593 & 601-603 Laurier Avenue West

UDRP REPORT
Official Plan and Zoning By-law Amendment Applications
June 15, 2025

URBAN DESIGN BRIEF

601 LAURIER AVENUE

1 WEST ELEVATION - ANDREW FLECK HOUSE  
A202 SCALE: 1:100

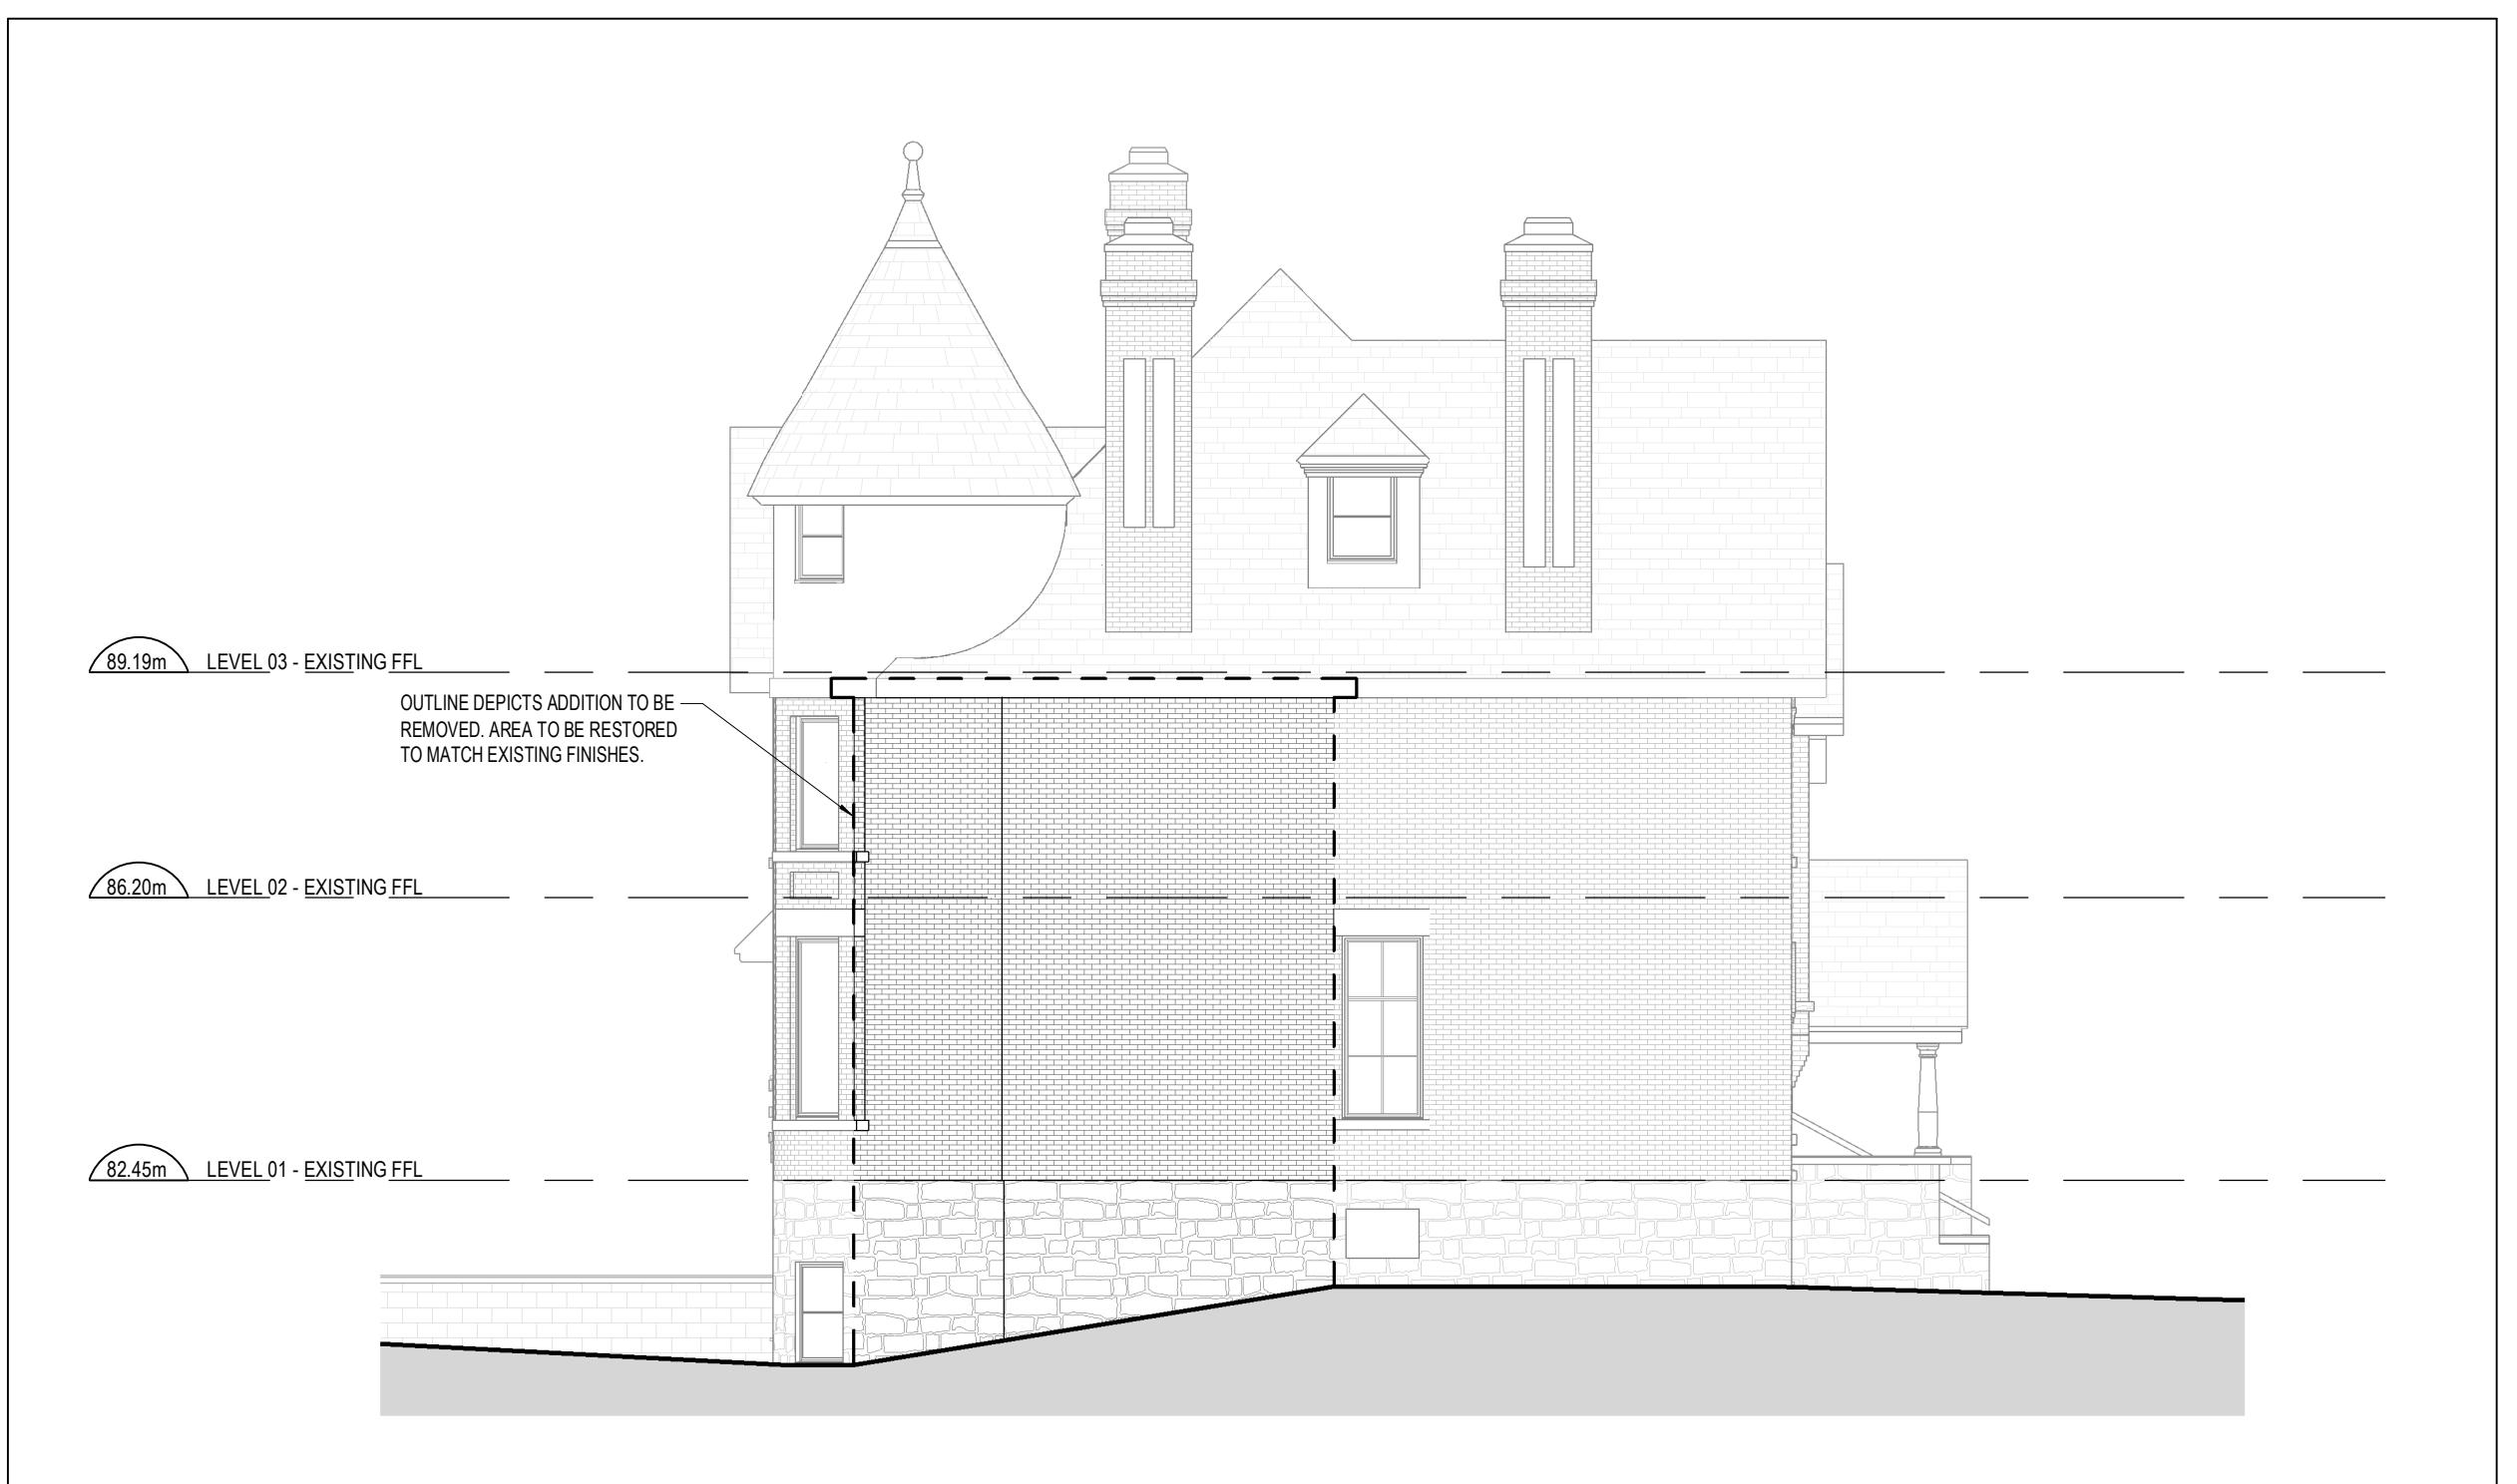
The podium may be high for the neighbourhood context and especially the relationship to the heritage house on the property. We recommend providing additional design/massing details so we may better understand the approach being taken.

We have increased the separation from the heritage house to 4.5m from 3m and introduced a setback and material change above level 4 to better integrate the podium with the neighborhood context. These adjustments help to mitigate the podium height and ensure a more harmonious relationship with the heritage house.
